June 21, 2016

RE: Proposed Northeast Air Signs

I have reviewed the building signs being proposed for Northeast Air's FBO building now under construction and have found sign numbers 1-3 described below to be compliant with the Portland International Jetport's Rules and Regulations.

8' wide x 4' high internal lit sign on concrete footing location - need power conduit to this location from the building

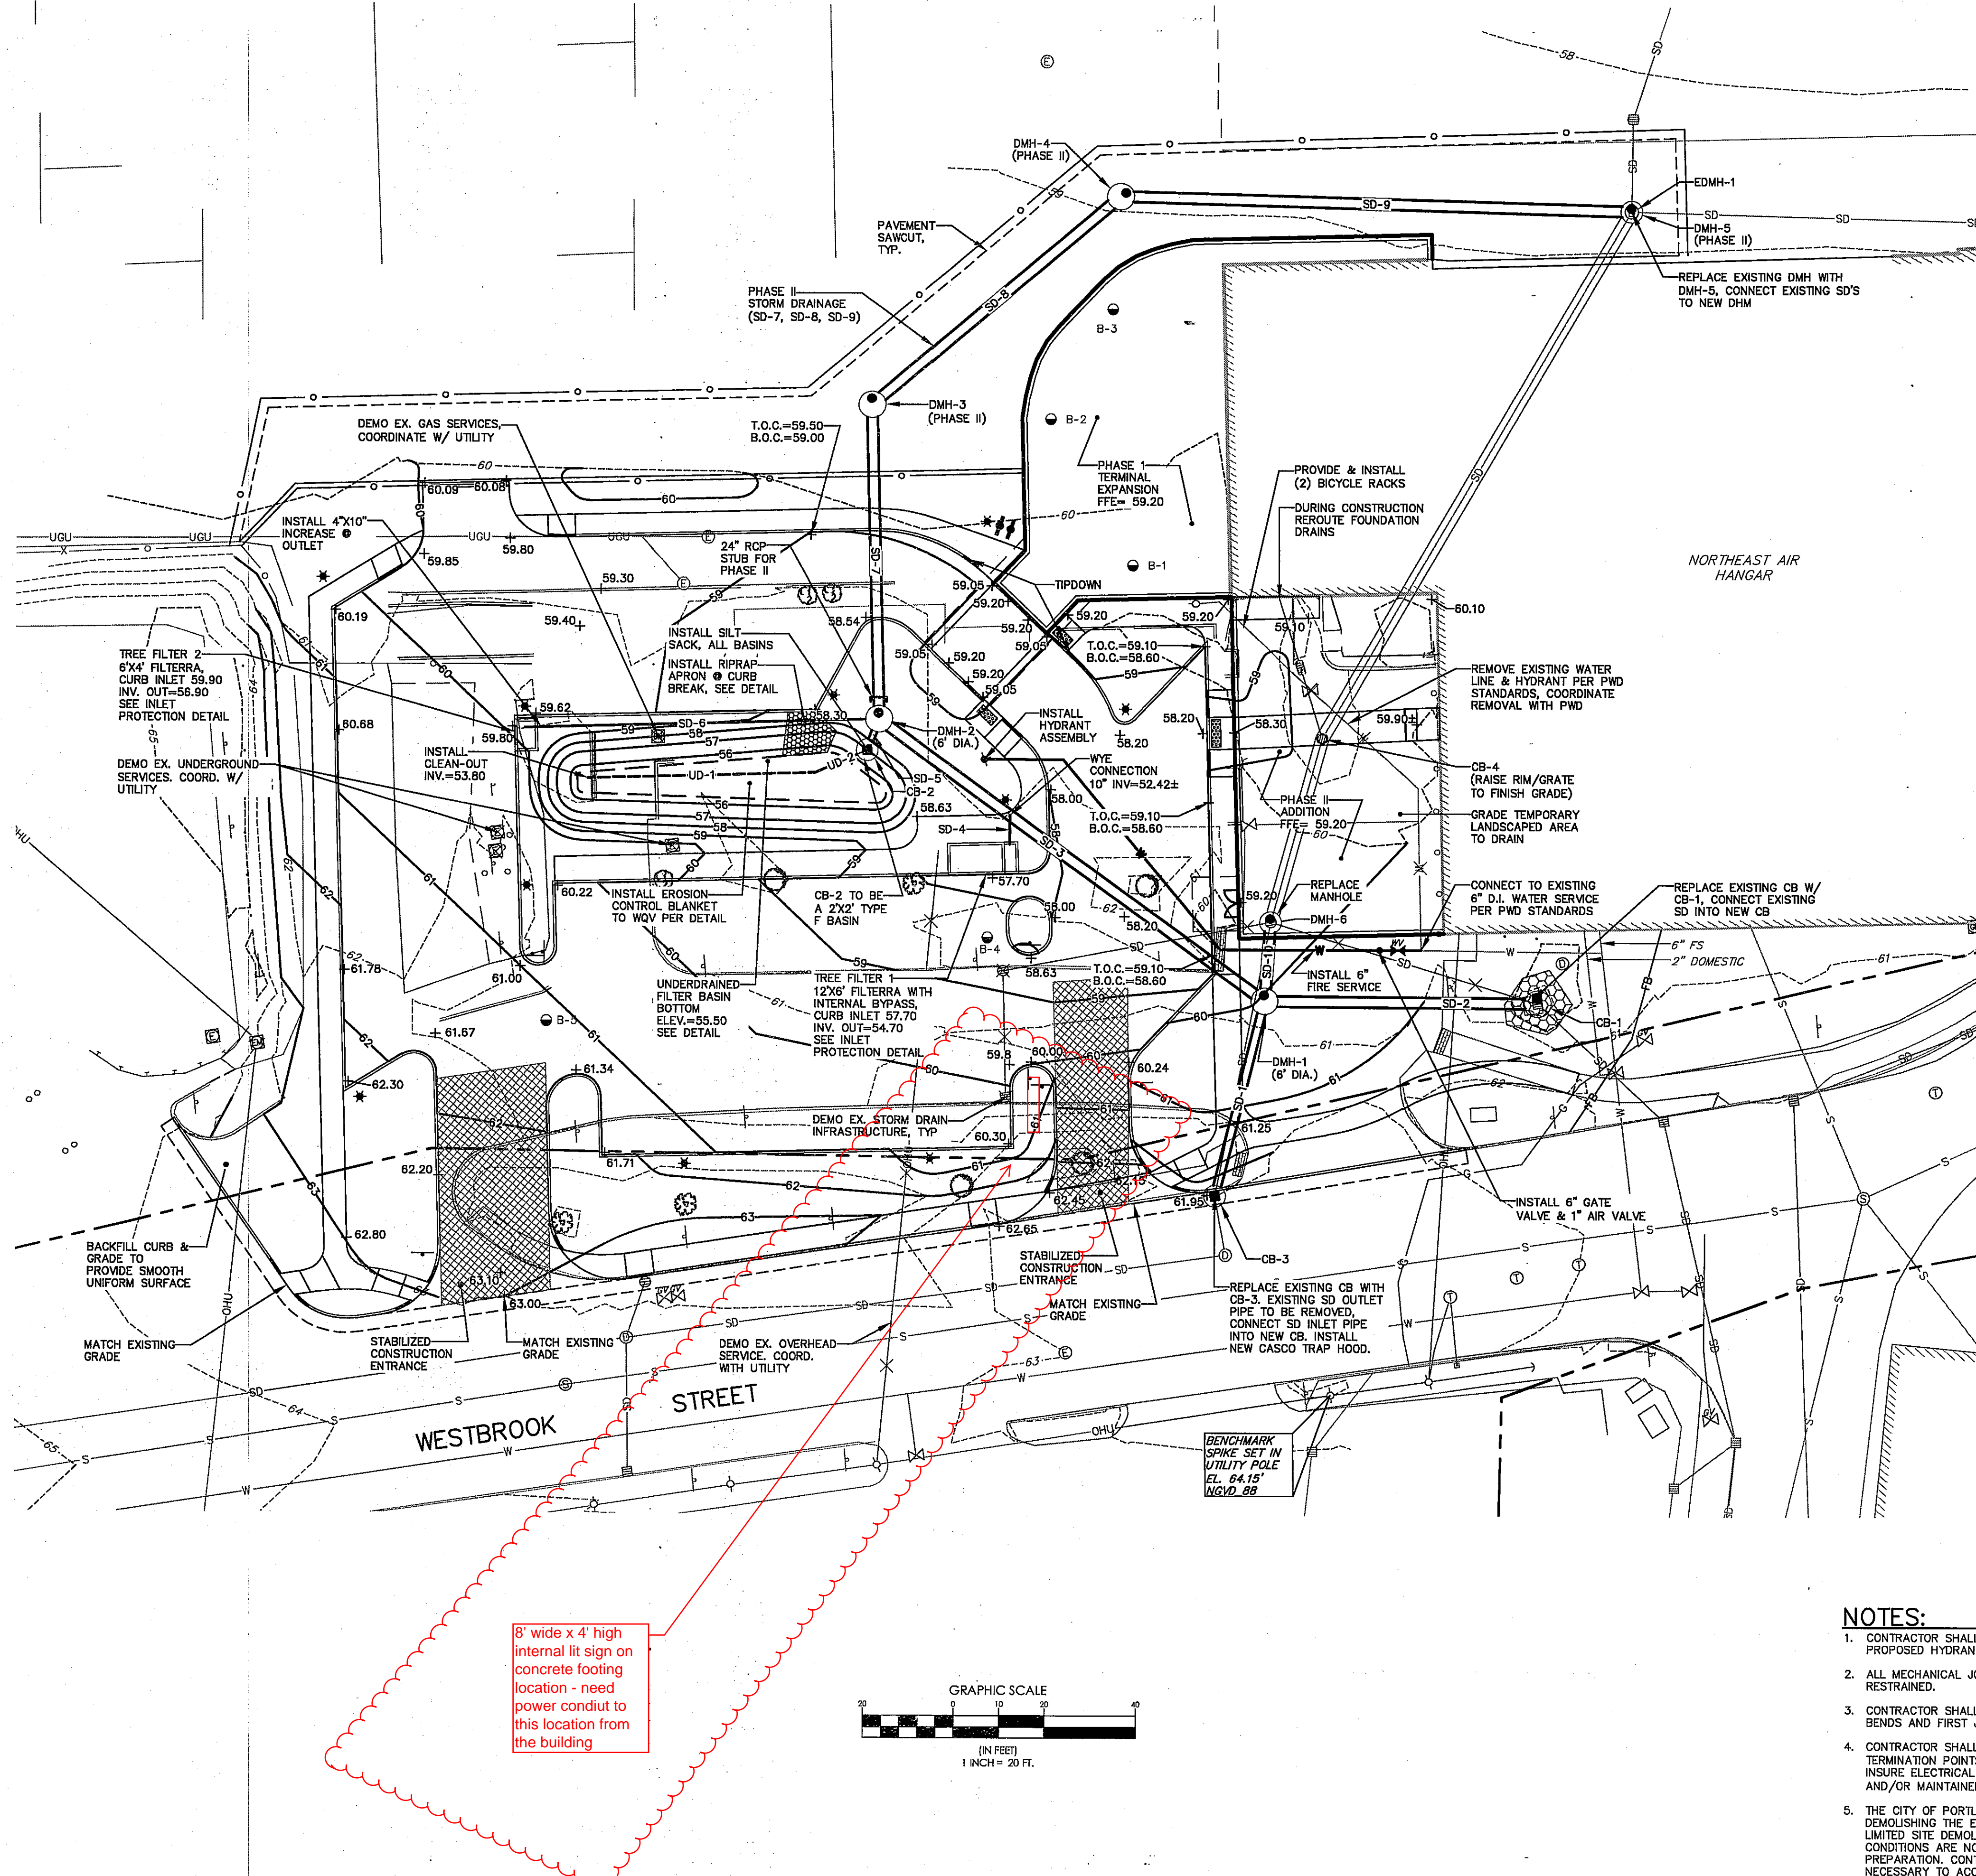
- Sign #1- Freestanding Sign on Westbrook St. with area of 60 square feet
- Sign #2 - Building Sign on west elevation of building with area of 37.5 square feet
- Sign #3 – Building Sign on north elevation of building with area 37.5 square feet

The Jetport Rules and Regulations reference City of Portland Code for signs in the Airport Business (AB) zone. Under these rules lots with facing street frontage of greater than 200' may have one sign with an area of no more than 65 square feet, a height of 16 feet or less, and a 5 foot setback. NEA's proposed sign #1 at 60 square feet and 10 feet high is compliant as sited with all these requirements.
